From: Laura Gibbons <Laura.Gibbons@arun.gov.uk>
Sent: 10 August 2021 08:43
To: Planning.Responses <Planning.Responses@arun.gov.uk>
Cc: Michael Eastham <Michael.Eastham@arun.gov.uk>
Subject: RE: Planning Consultation on: WA/63/21/PL

Surface Water Drainage/ Land Drainage Comments

Application No: WA/63/21/PL
Registered: 29th June 2021
Site Address: Land East of Tye Lane Walberton BN18 0LU
Grid Reference: 497404 106234
Description of Works: Proposed alternative vehicular accesses off Tye Lane and emergency access off Avisford Park Road, along with minor highway works following WA/95/18/RES (resubmission following WA/93/20/PL). This site is CIL Zone 2 (Zero Rated) as other development.

Drawing Title:
PROPOSED ALTERNATIVE ACCESS

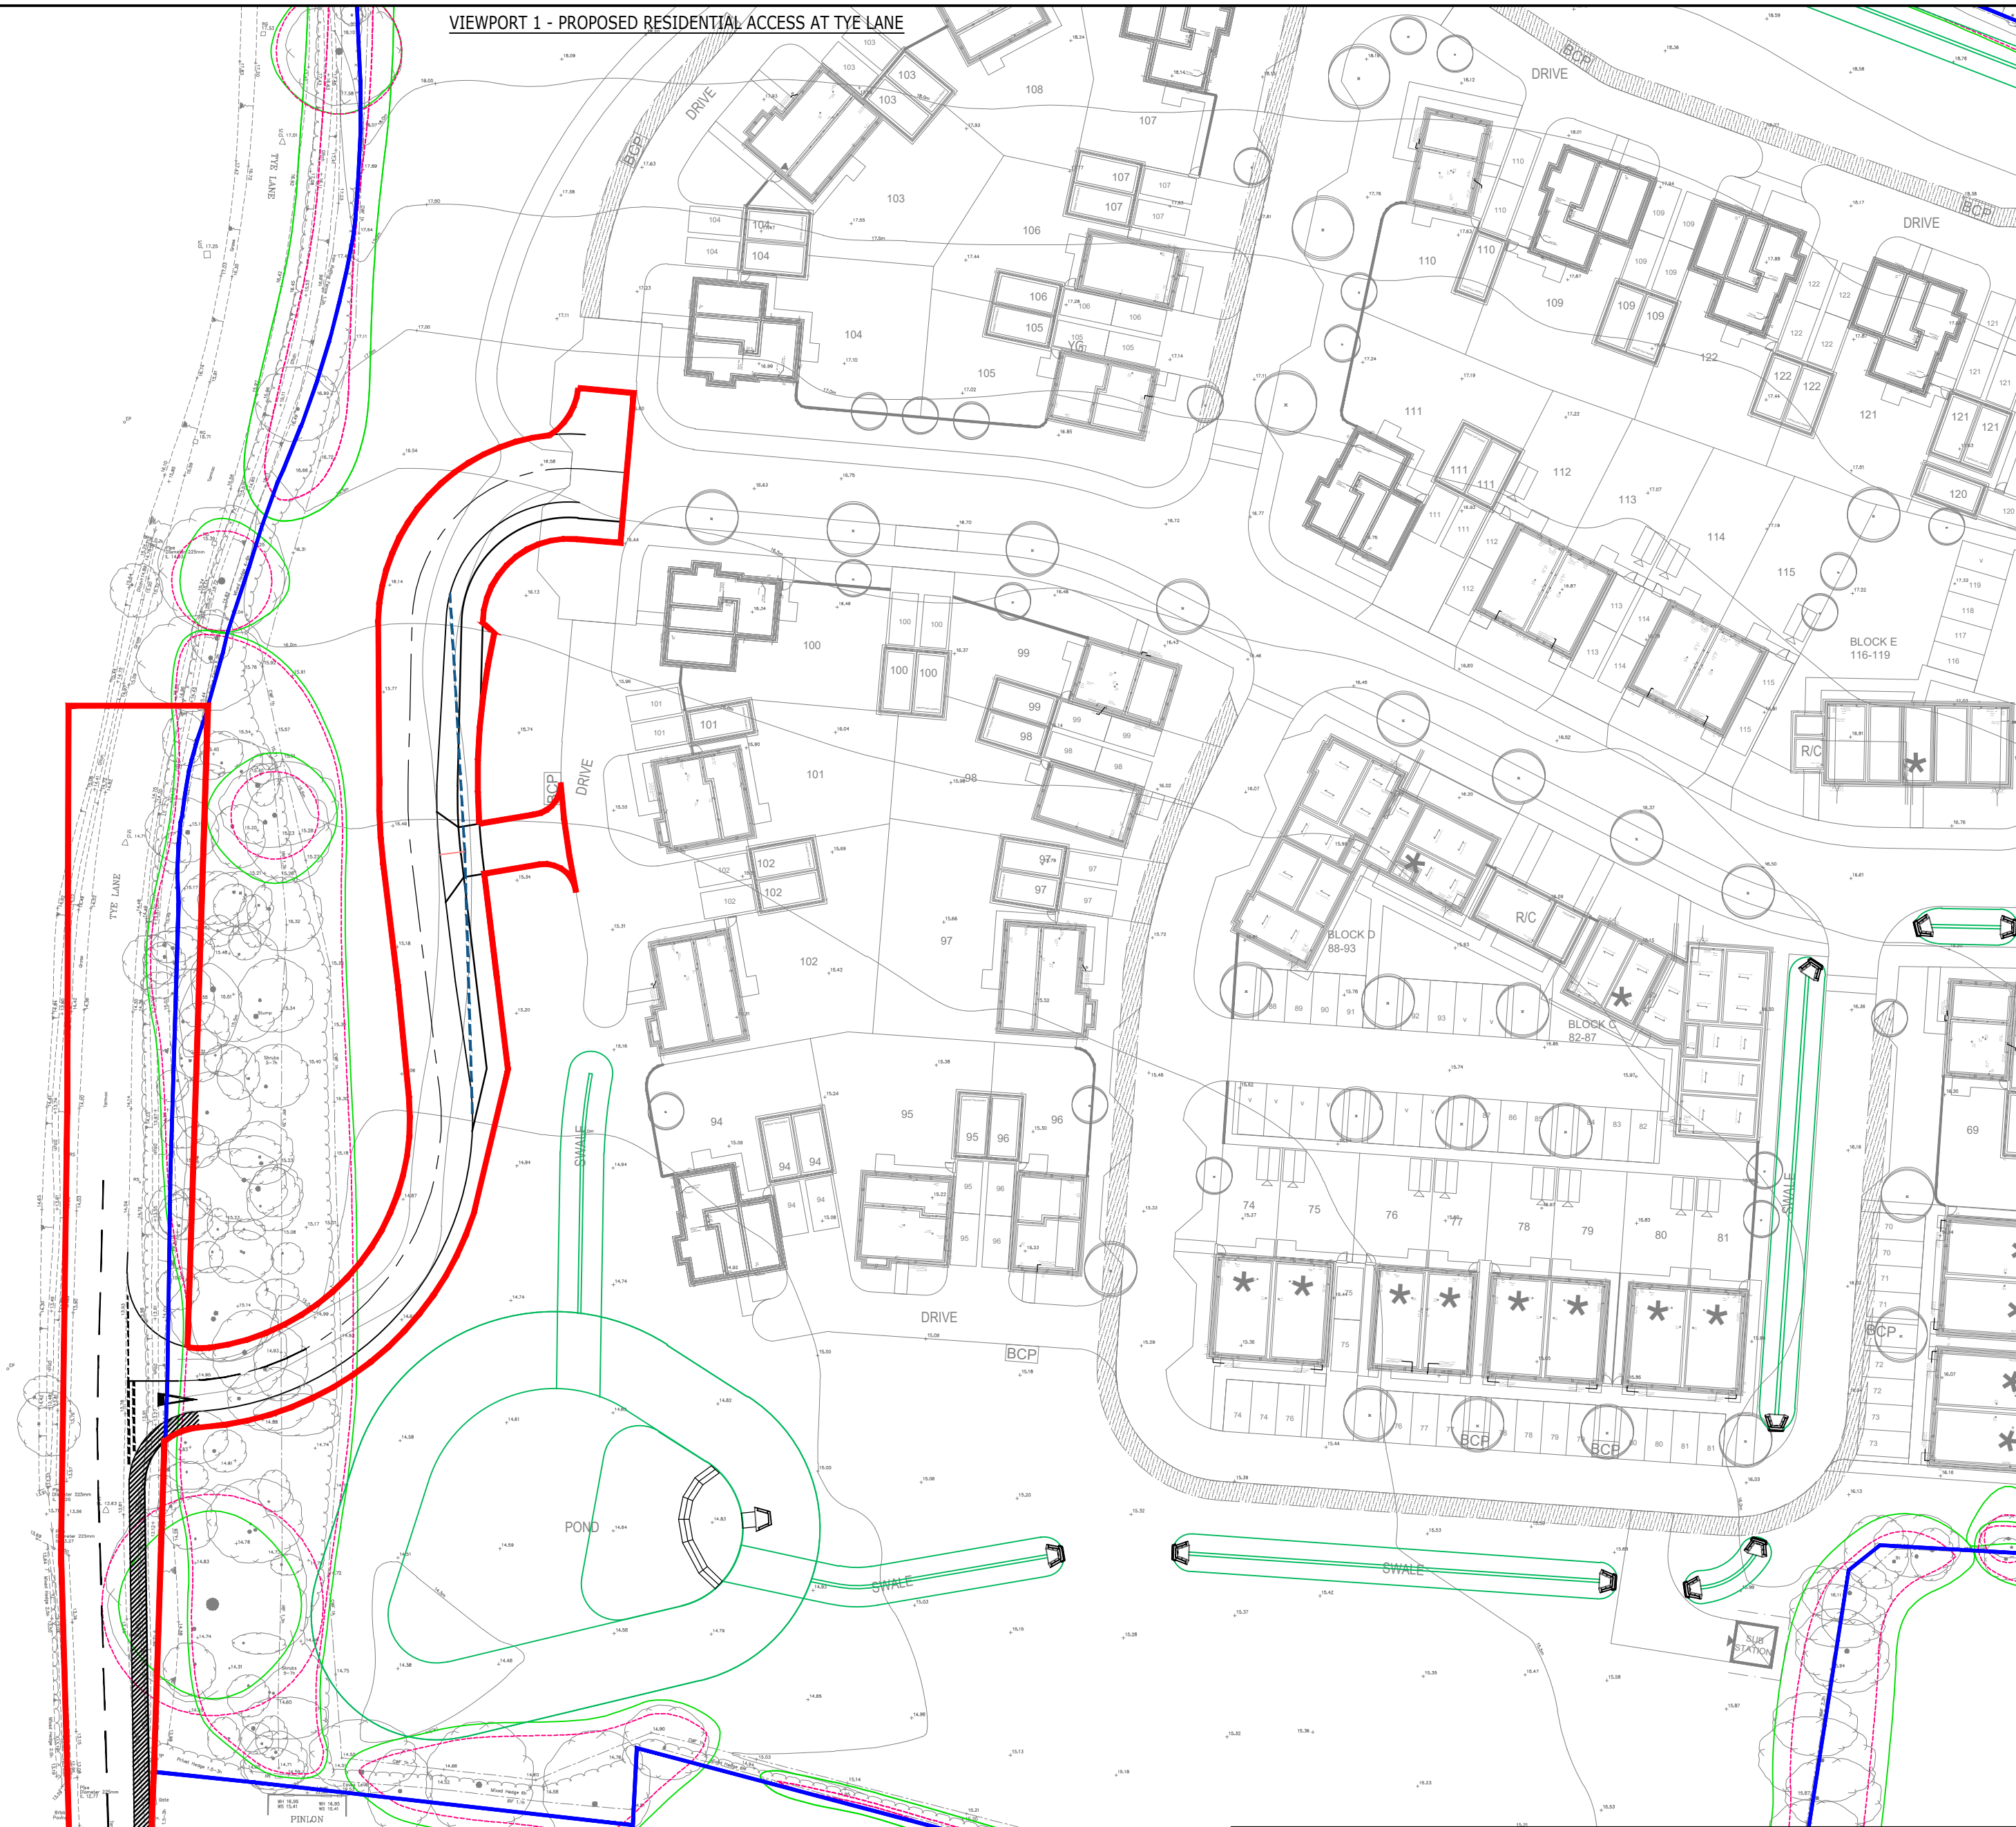
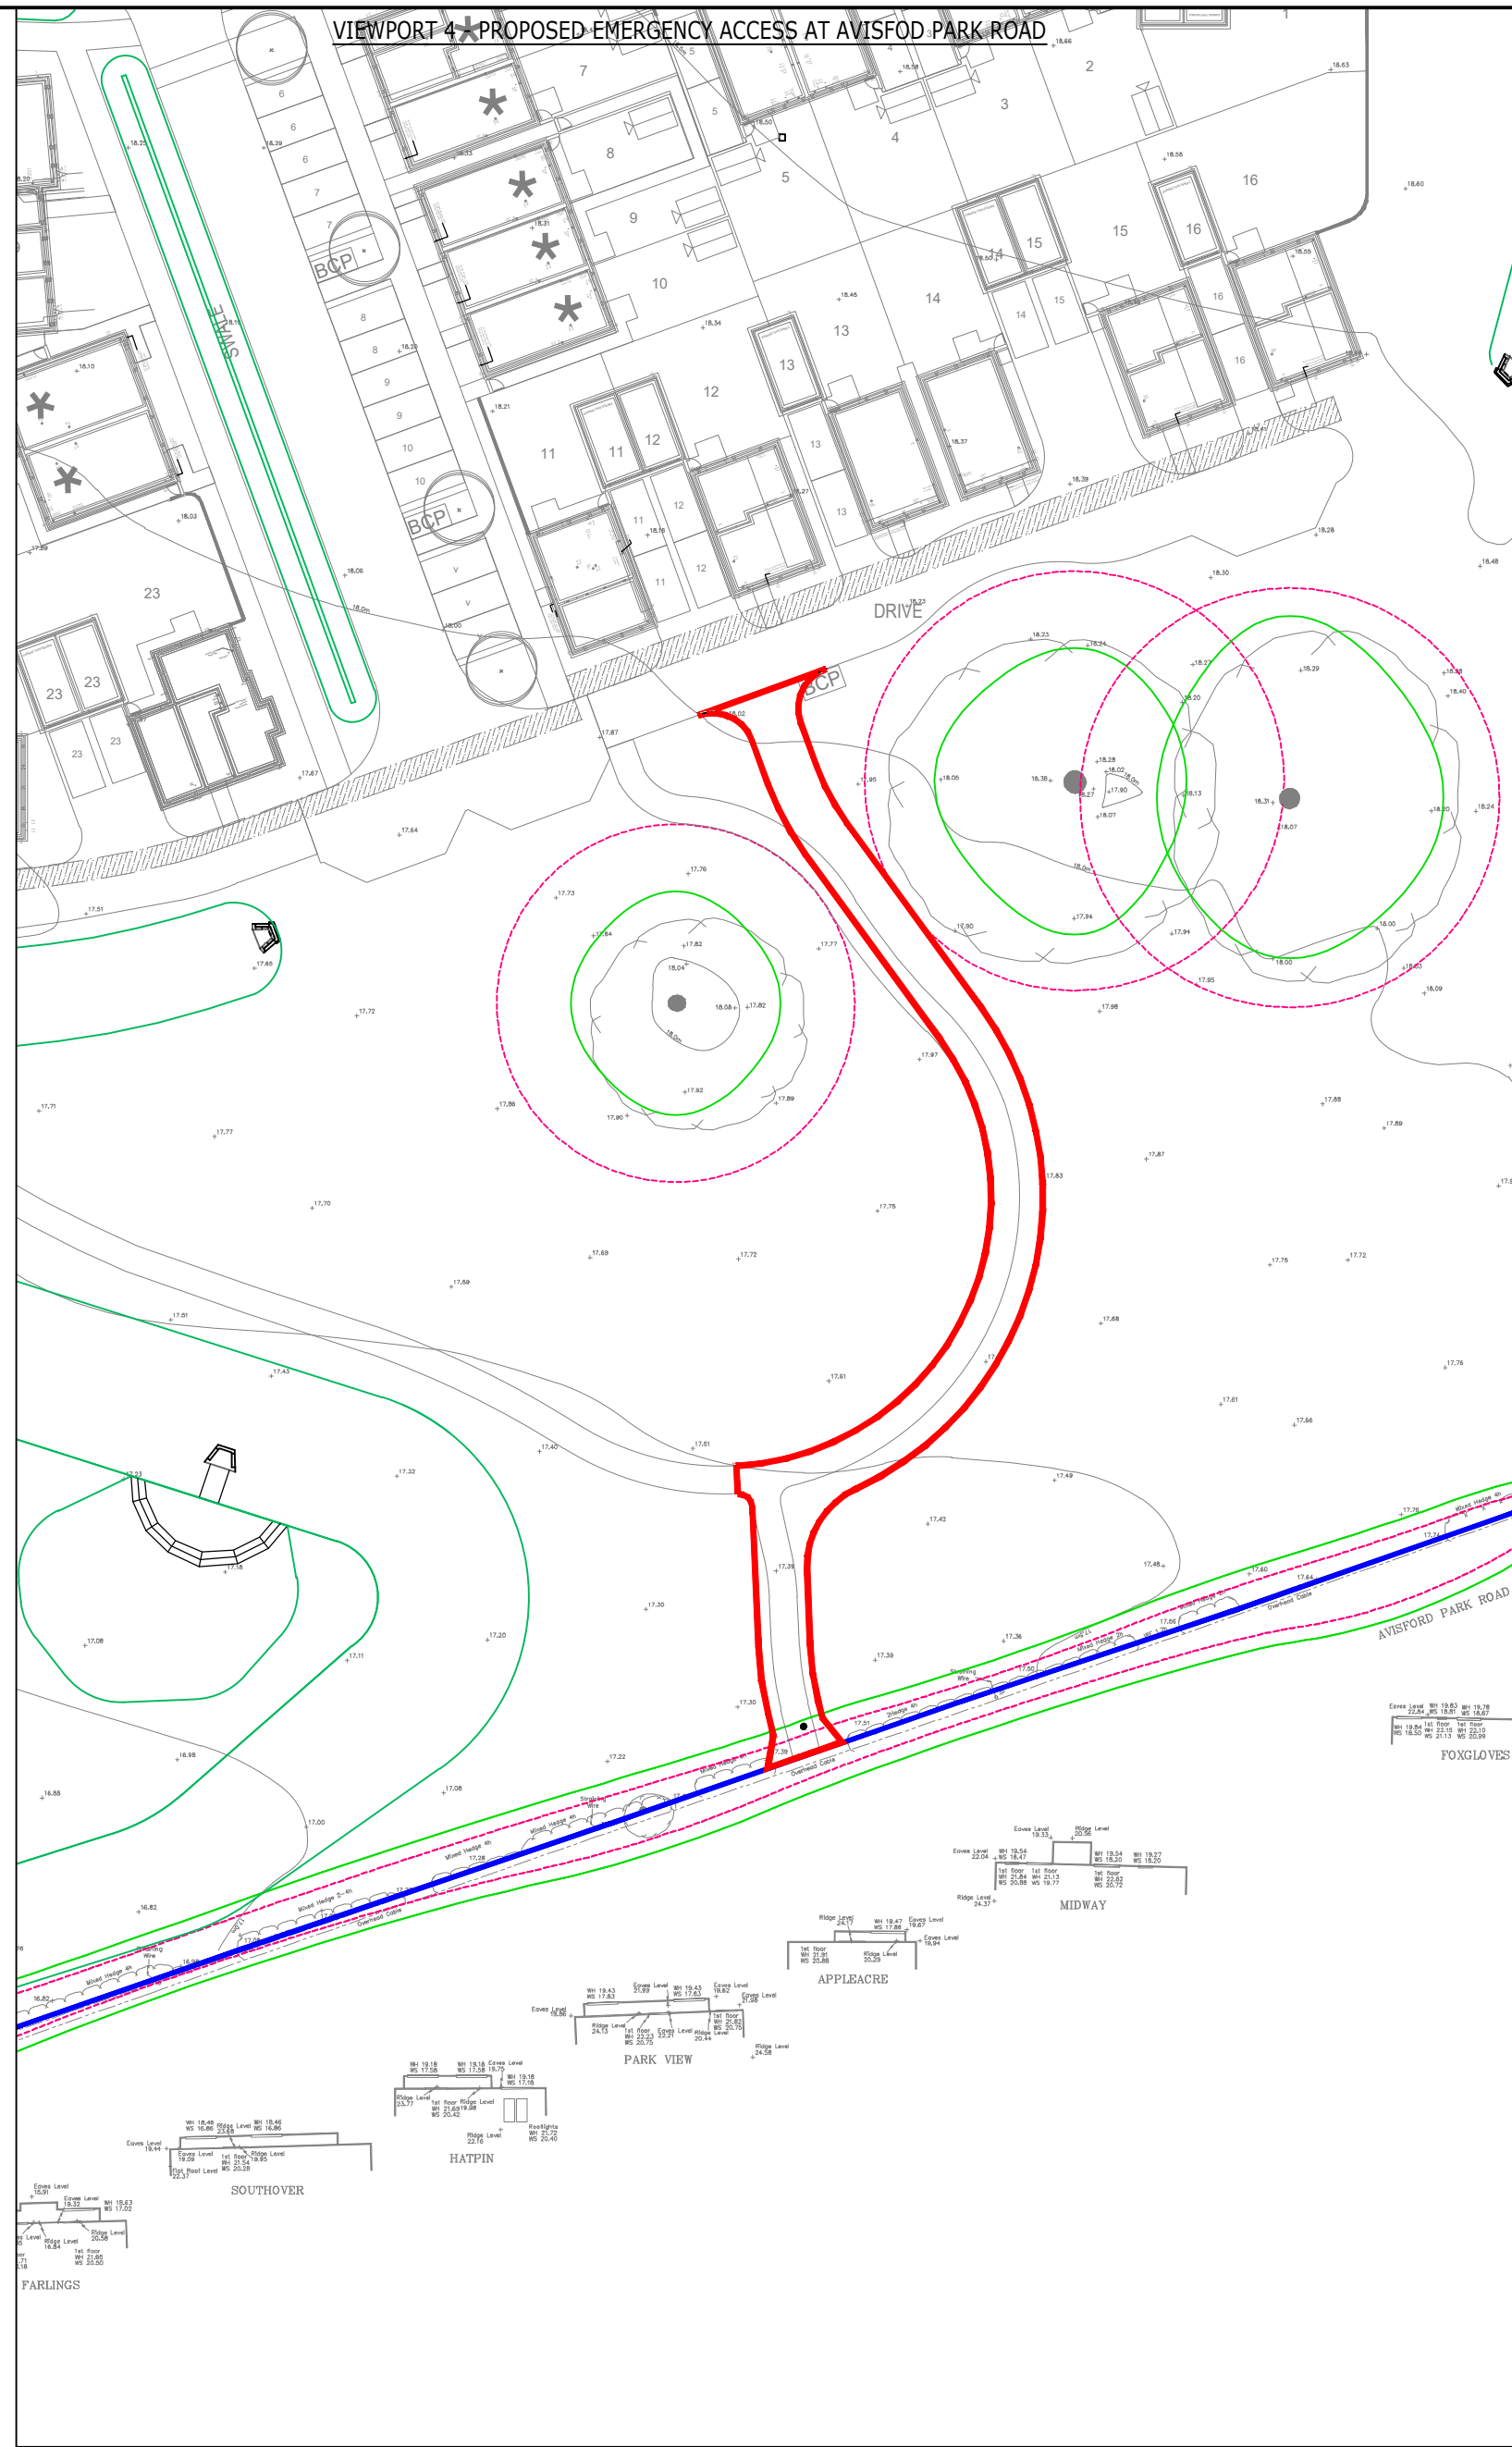
As per our comments to WA/93/20/PL we object to this application. Despite our previous requests it appears that no further information regarding the impact of the proposed accessway and footpath on the watercourse along Tye Lane have been provided.

The proposed access will need to cross the watercourses which runs along the eastern edge of Tye Lane. It is understood that this application will increase the width of the crossing from that previously approved. The proposed footpath along the eastern highway edge appears to require the infilling of the watercourse, this is not supported.

Please can the applicant submit details of the proposed ditch crossing, details of the proposed footpath location in relation to the watercourse, details of the proposals for the watercourse including drawings and a statement. As per WSCC policy, we will not support proposals to remove, narrow, or culvert a long stretch of this watercourse.
